**From:** Eisenberg, Jame J.  
**Sent:** Friday, June 12, 2015 2:46 PM  
**To:** Daggett, Kevin  
**Cc:** Harmon Rita T.  
**Subject:** RE: Amole Del Norte Detention Pond [Amole Del Norte Dam (OSE File No. D-577)]

The Grading and Drainage Plan and report for Paradise RV Park Phase II has been submitted. This site is just north of the Amole Del Norte Detention Pond. Roland Penttila had originally reviewed this plan in August, 2011 and felt it was acceptable. The developer has just recently resubmitted a revised plan, but this plan proposes 2 outfalls into the pond. With 2 outfalls, as opposed to the original single outfall, will this new plan still be acceptable? The engineer is willing to go back to 1 outfall if absolutely necessary.

**From:** Harmon Rita T.  
**Sent:** Friday, July 24, 2015 3:23 PM  
**To:** [ron@thegroup.cc](mailto:ron@thegroup.cc)  
**Cc:** Biazar, Shahab  
**Subject:** Paradise RV Park

CITY OF ALBUQUERQUE PUBLIC WORKS DEPARTMENT ENGINEERING DEVELOPMENT GROUP			
PARADISE RV PARK PHASE 2 VOLCANO STORM STA. 13+60 - 16+50 PLAN AND PROFILE			
DESIGN REVIEW COMMITTEE	CITY ENGINEER APPROVAL	LAST DESIGN UPDATE	Mo./DAY/YR.
CITY PROJECT No. 676280		ZONE MAP NO. K-08	SHEET 5 OF 11

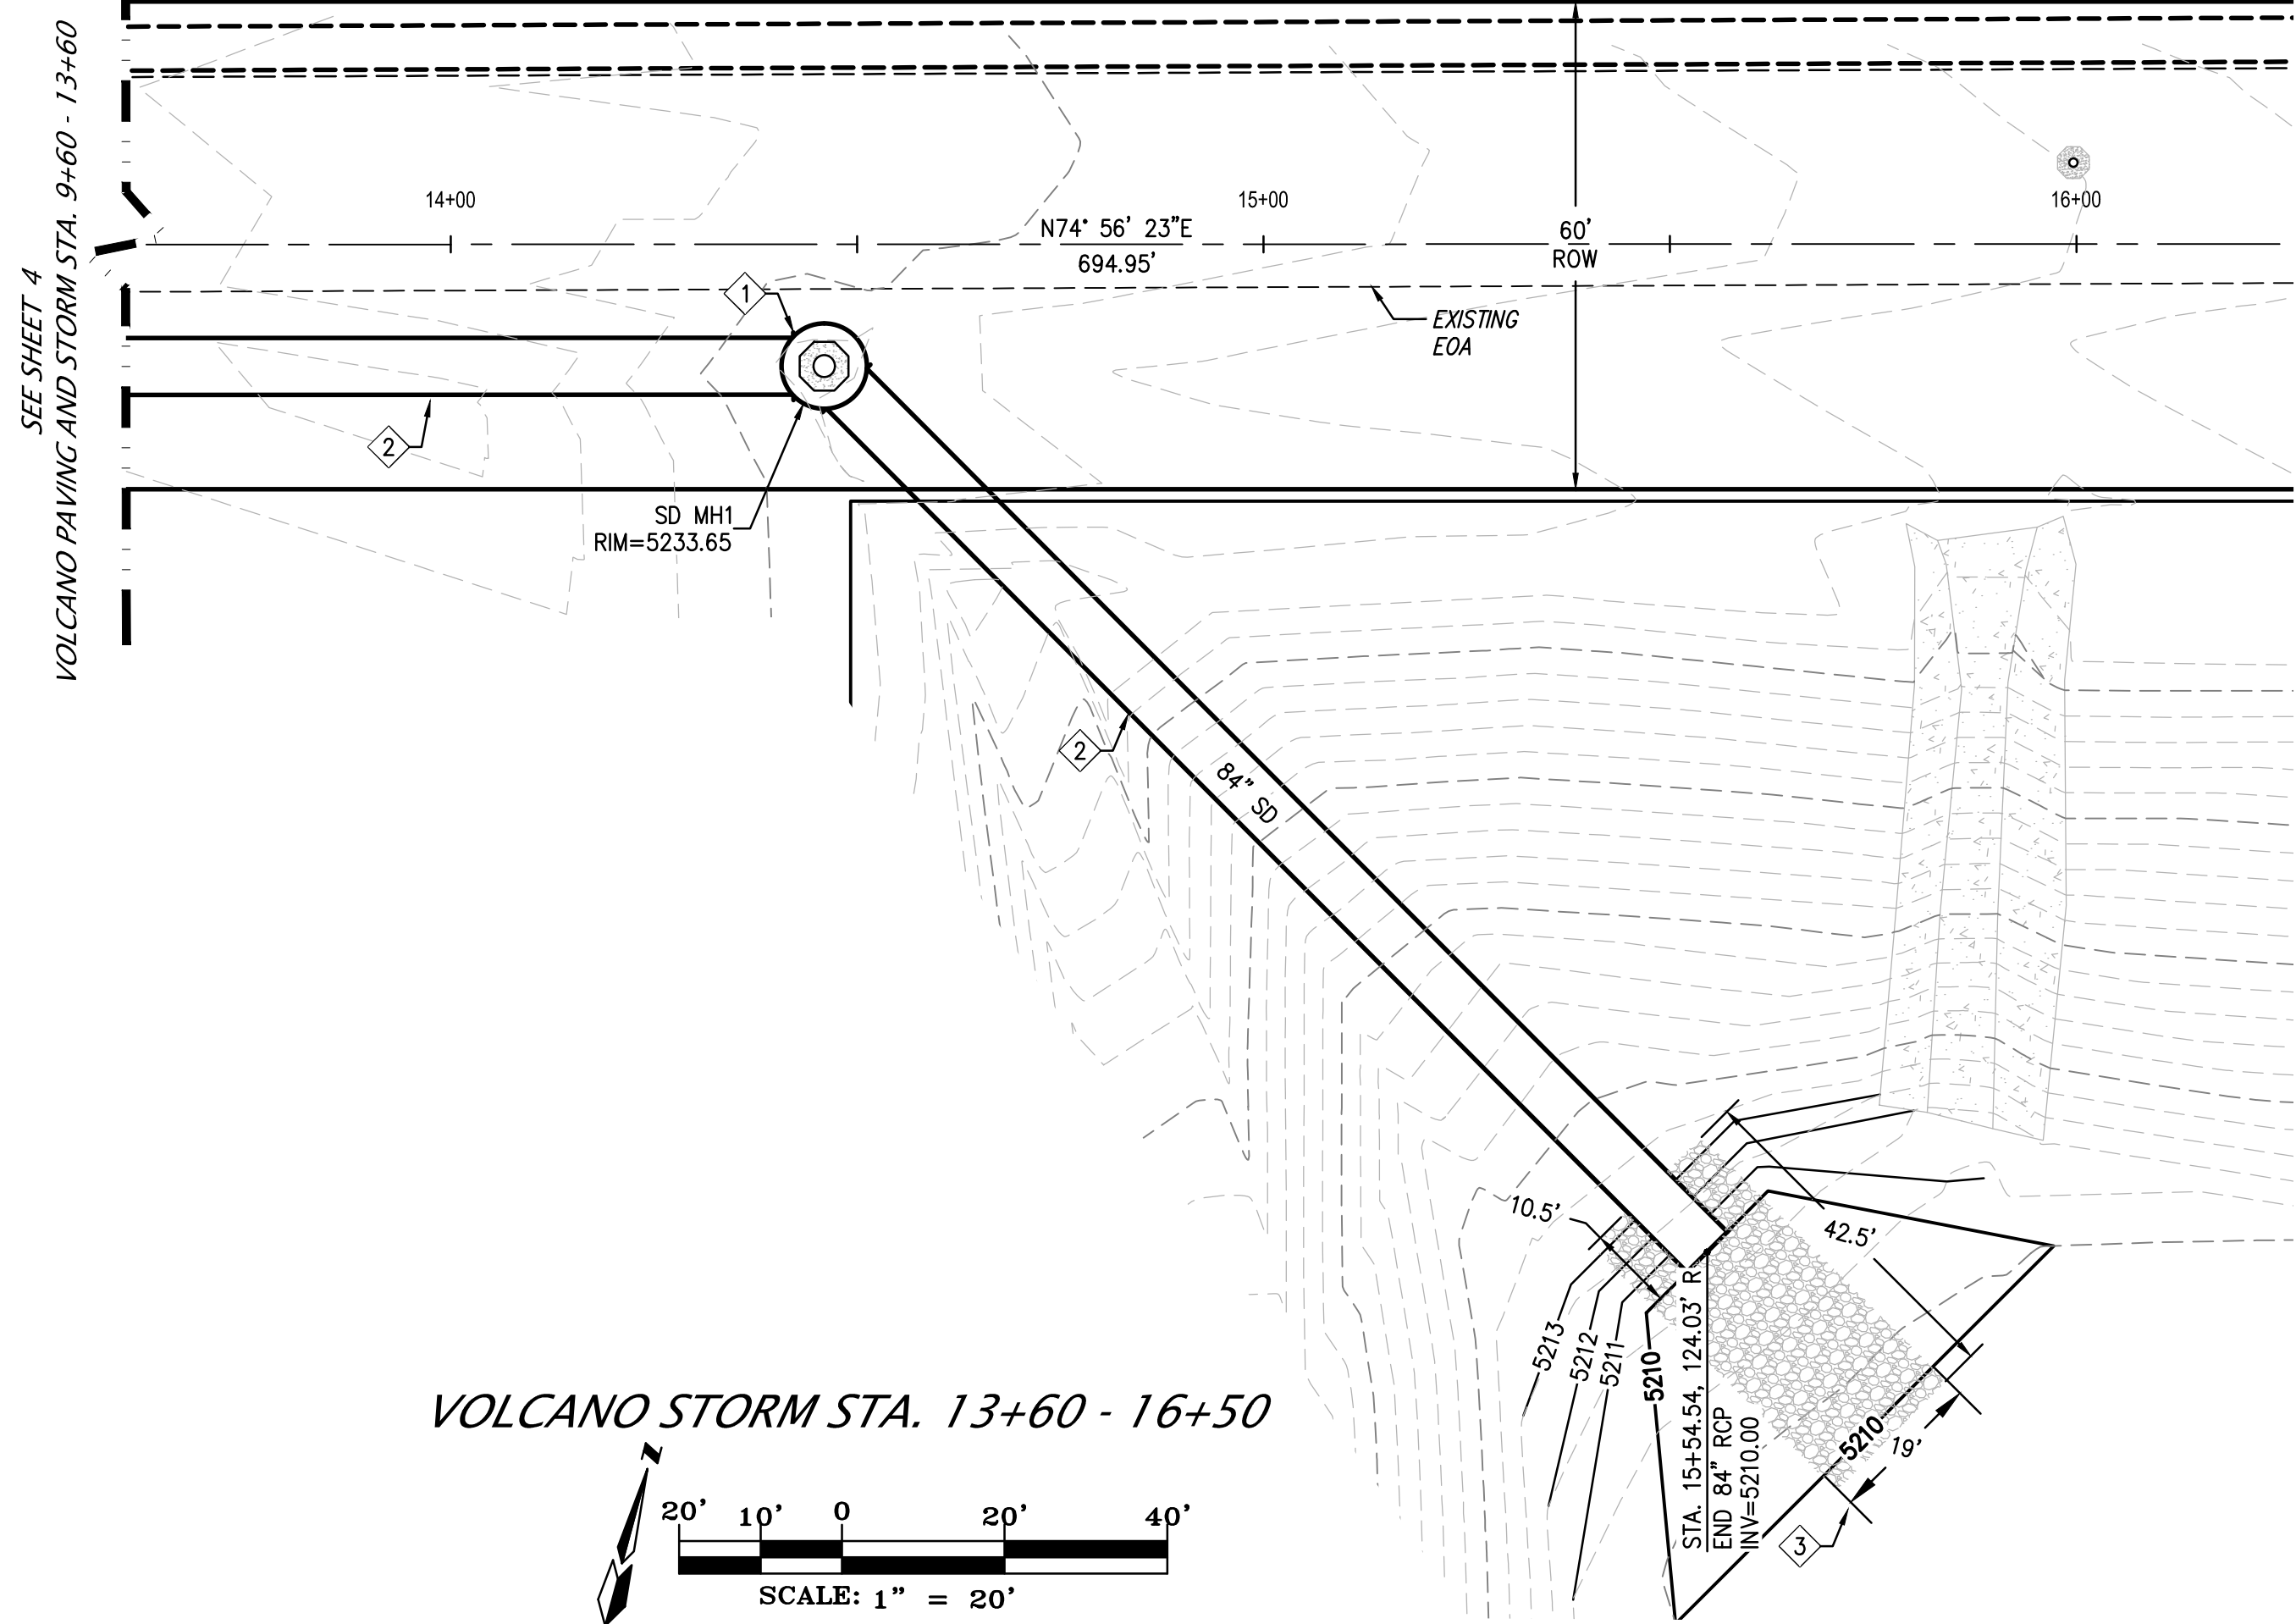
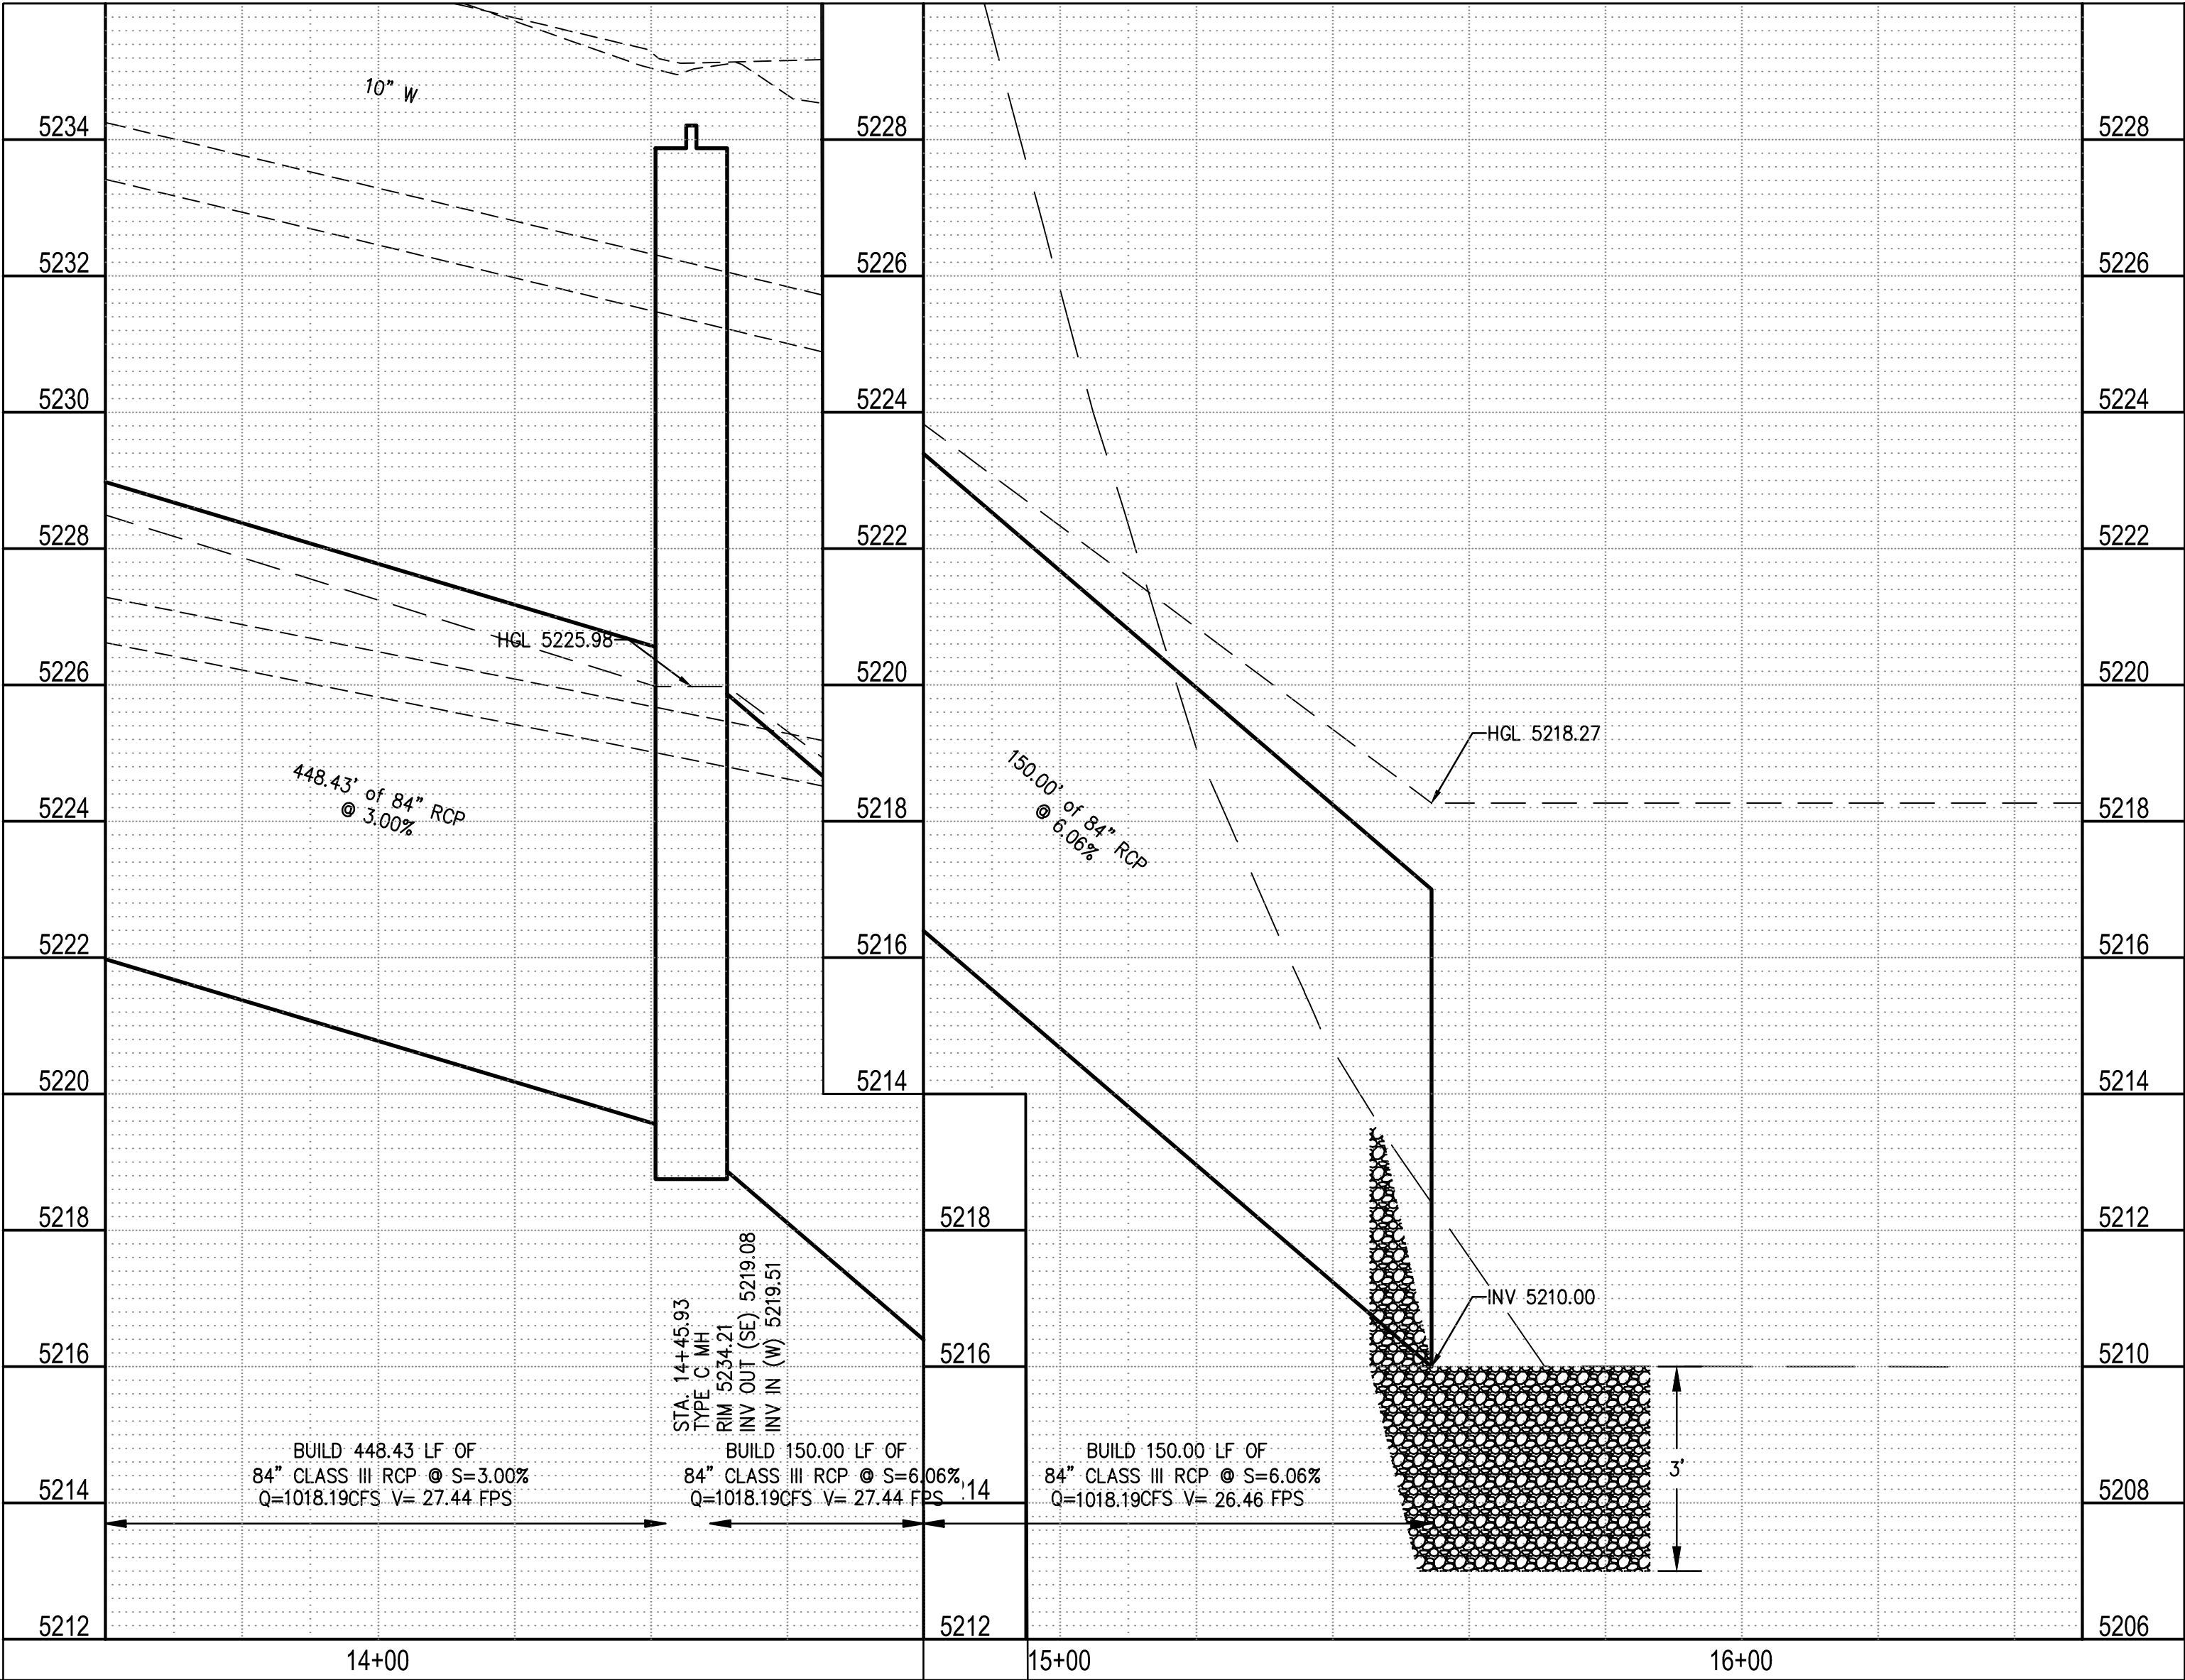
- a. Cut Basin 205.1 in half along 106<sup>th</sup> St. and route western half to Basin 204.1. Reason being that the 84" SD to S. Pond was sized for 334cfs. With all of Basin 205.1 discharging to SD in 98<sup>th</sup> St, the peak flow is 361 cfs- may be too high. Note: With half of Basin 205.1 being routed to the 72" storm drain in Volcano, the pipe may need to be upsized.

- b. AHYMO needs to be rerun with the Basins immediately west of 98<sup>th</sup> Street being routed to the South Pond. They are being added to flows in Volcano SD and then routed to N. Pond (see AHYMO summary). They should be routed directly to the S.Pond.

- i. This may change the analysis for the 102" SD, since 361 cfs being re-routed.

- ii. What is the HGL in the 72" with this change? We may be able to leave as 72" rather than upsize.
  - c. Use the Staged discharge Curve using the Tierra Bayita III 1998 Report as it included the access road.

- 7) The outfall of this site into the Dam needs further discussion. I am asking DMD for clarification of whether or not a SD can outfall into the Dam, or did they prefer a concrete rundown. They do want a v-ditch/channel on the south side of Volcano Road to direct offsite flows into the Dam, and also for the Concrete Rundown to be modified as needed.

I need a little clarification: Was it ok for the developer to discharge his site into the Dam using an underground SD? He cannot use a rundown since the SD from his site is at 5222 and the top of the Dam is at 5230.

Ron,  
You can discharge into the pond via Storm drain as opposed to a rundown.

I'd like to change my response regarding this question. 19.25.12.19 NMAC requires that approval must be received from the state engineer to reconstruct, enlarge, modify, restore reservoir capacity, repair, remove or breach an existing dam. Based on internal discussion, we do not believe placing the inflow pipe deeper at the upstream end of the reservoir would be considered a modification to the dam, requiring coordination with the DSB, since it is not impacting the dam embankment or changing the inflow (inflow to the reservoir was anticipated to be pipe flow for the fully developed watershed).
